July 24, 2024
Project #010014-01-218

RE: PR-2021-004973 CHICK-FIL-A 1600 GIBSON BLVD SE – RESPONSE TO CYCLE 1 REVIEW

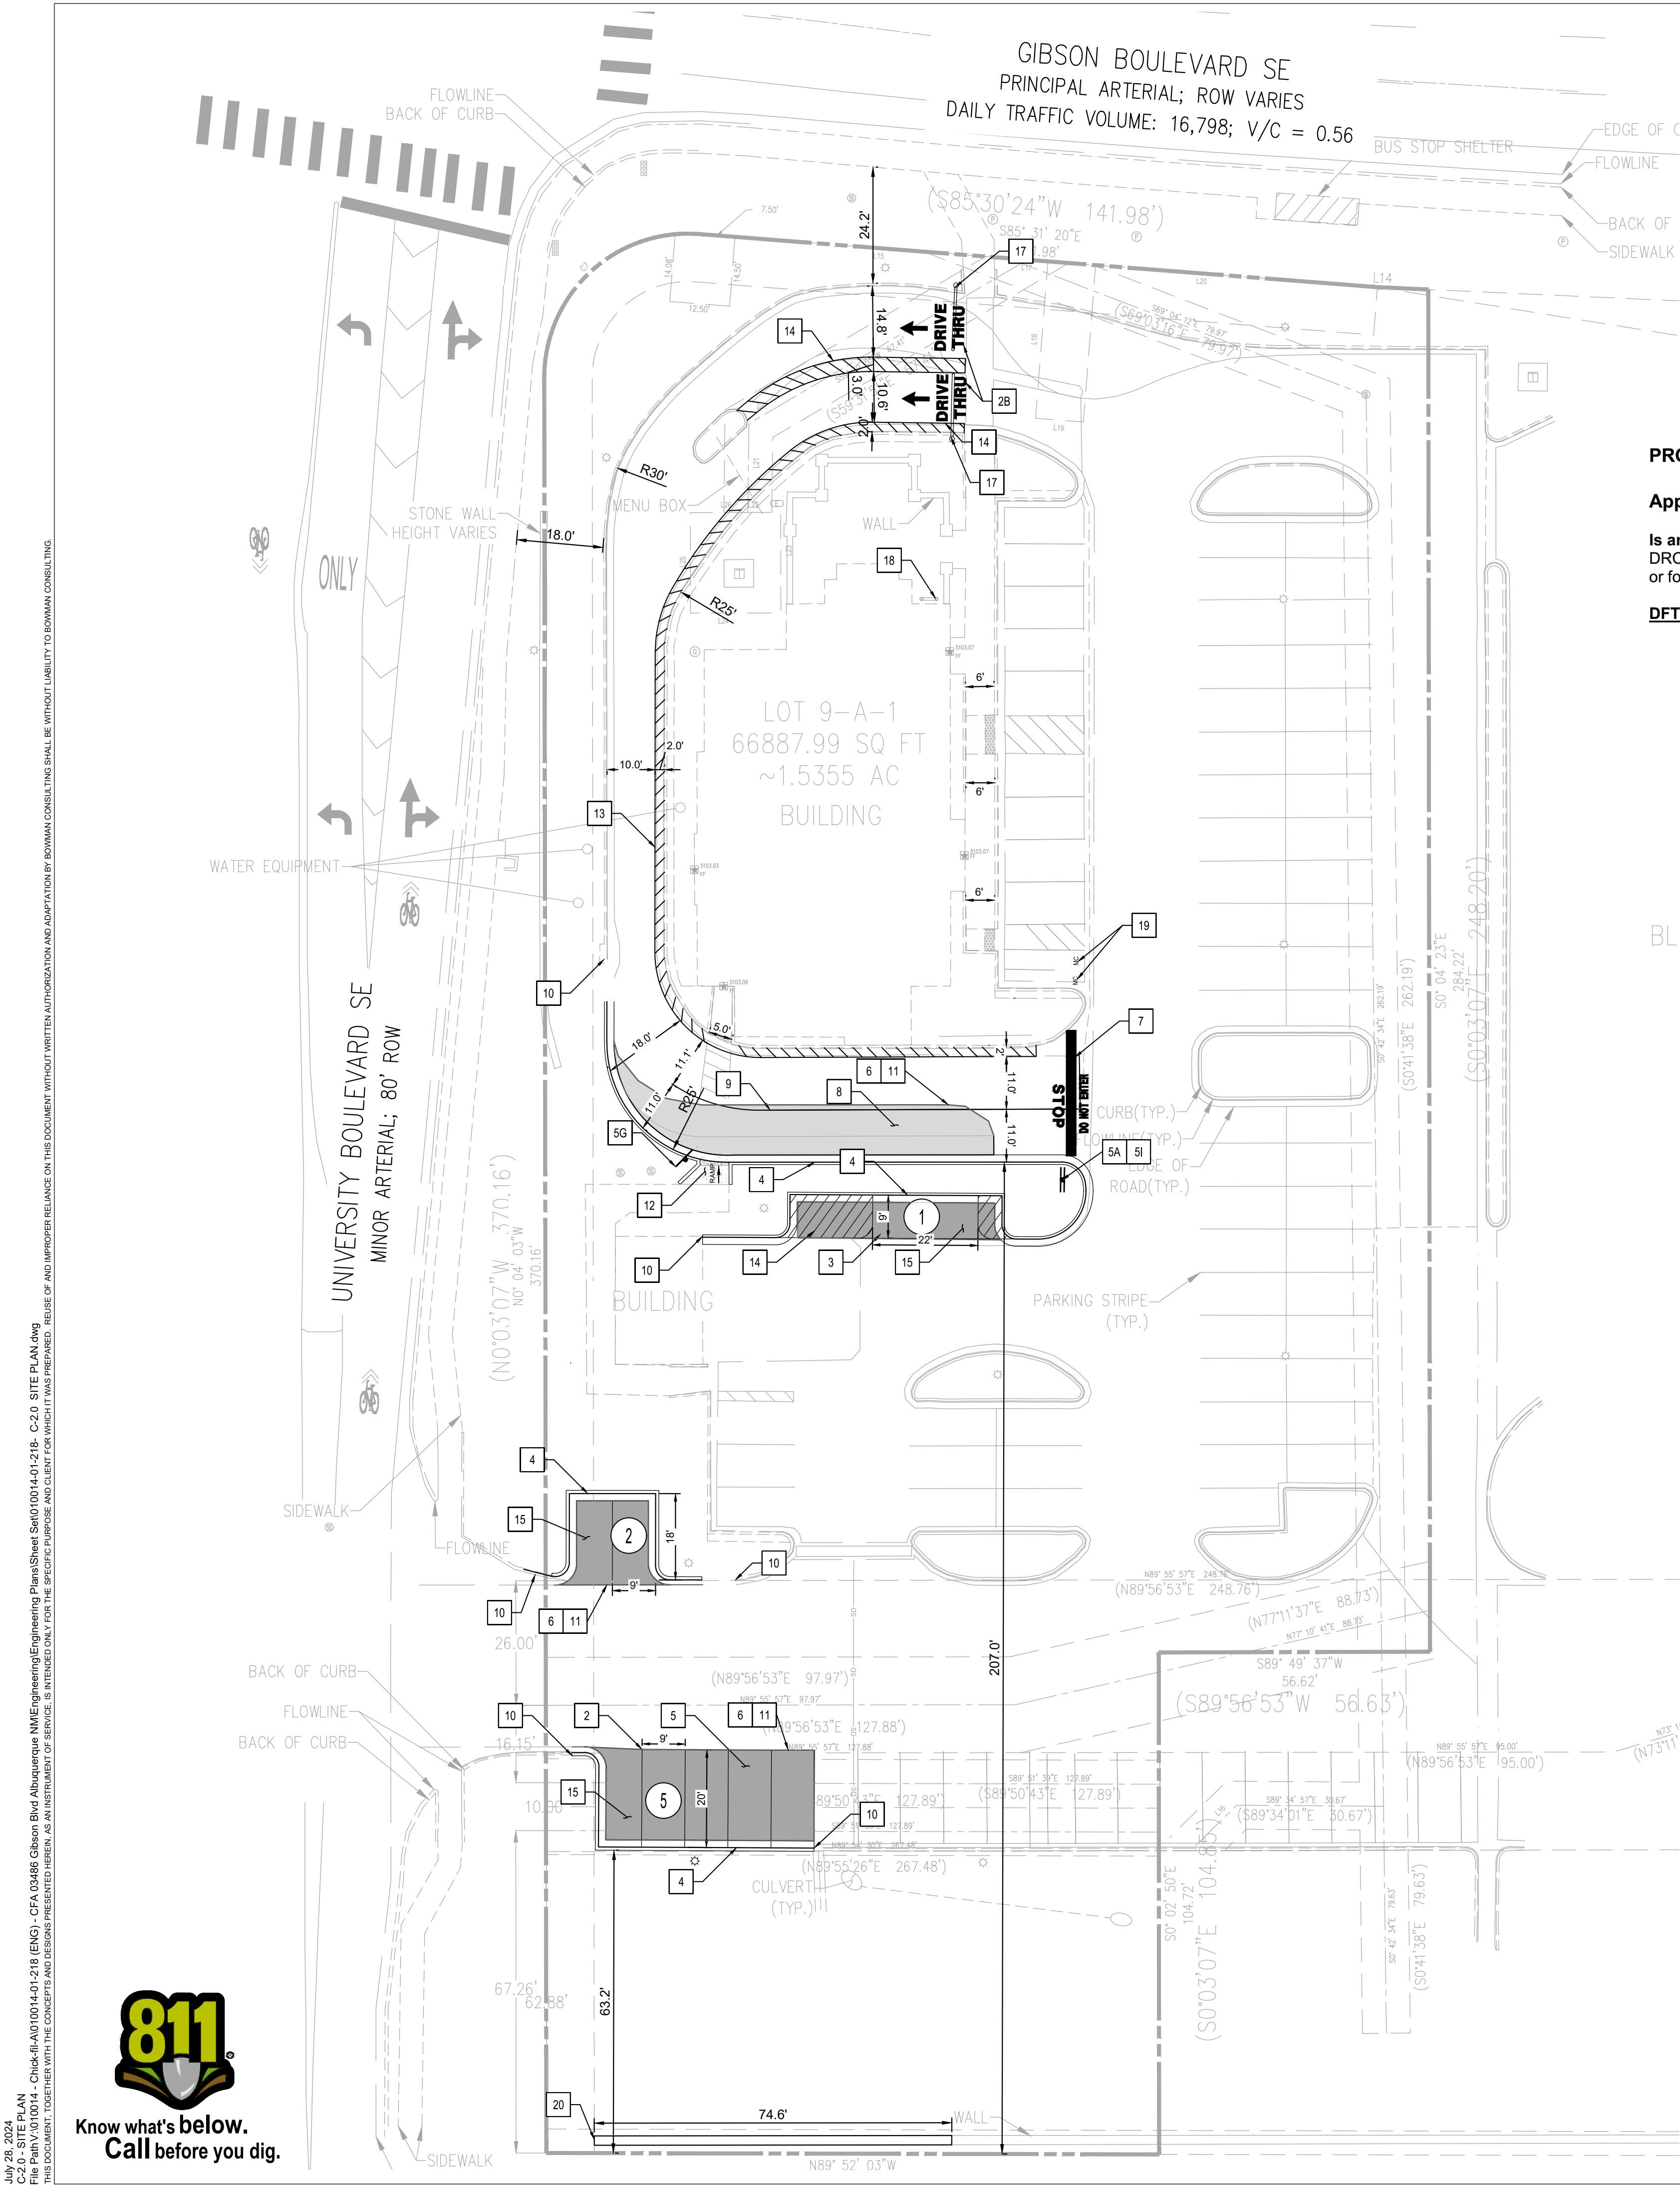
5. 4-3(F)(5)(b) This use shall comply with the provisions of Section 14-16-5-5 (Parking and Loading). Confirm compliance with the following IDO section:

5-5(l)(2) Drive-through or Drive-up Facility Design

5-5(l)(2)(a) Drive-through lanes adjacent to public right-of-way shall be screened by a landscape buffer area at least 6 feet wide containing a vegetative screen or wall constructed of a material similar in texture, appearance, and color to the street-facing façade of the primary building (but excluding exposed concrete masonry unit (CMU) block) at least 3 but not more than 4 feet tall. The landscape buffer area shall be provided on the public street side.

6. Confirm compliance with Section 14-16-5-9 (Neighborhood Edges). Confirmation must be provided on the Site Plan and in a comment response letter how these Neighborhood Edge requirements per 5-9(D) of the IDO are being met and/or will be met.

Protected Lot, a minimum of 6-foot-high opaque wall or fence shall be required to visually screen the parking or circulation area. Chain link fence with slats shall not constitute acceptable screening.

7. Clarify compliance on the Site Plan and in a comment response letter with Section 7 of the DPM Table 7.2.29 regarding sidewalk/landscape buffer zone width requirements along University and Gibson Boulevard.

Response: Landscape buffers on both Gibson Blvd and University Blvd exceed 6' in width. There is a screening wall along University Blvd and vegetative screen on Gibson Blvd. Dimensions added to sheet C-2.0 – Site Plan. There are no proposed changes to the building which would affect drive-through service window orientation or existing automobile service order devices.

Response: Existing 6' high opaque screening wall to be extended to cover the length of the southern property line. Please see sheet C-2.0 – Site Plan. Dimension added to show distance of drive-through lane and parking lot from the southern property line. Truck loading areas not located between Regulated Lot and Protected Lot. Per IDO 5-5(H)(1), truck loading spaces not required for non-residential uses with less than 25,000 GFA.

Response: Dimensions of sidewalks and landscape buffers shown on sheet C-2.0 – Site Plan. Sidewalk and buffer on both Gibson and University comply with the requirements of Section 7 of the DPM. Please see attached justification letter.
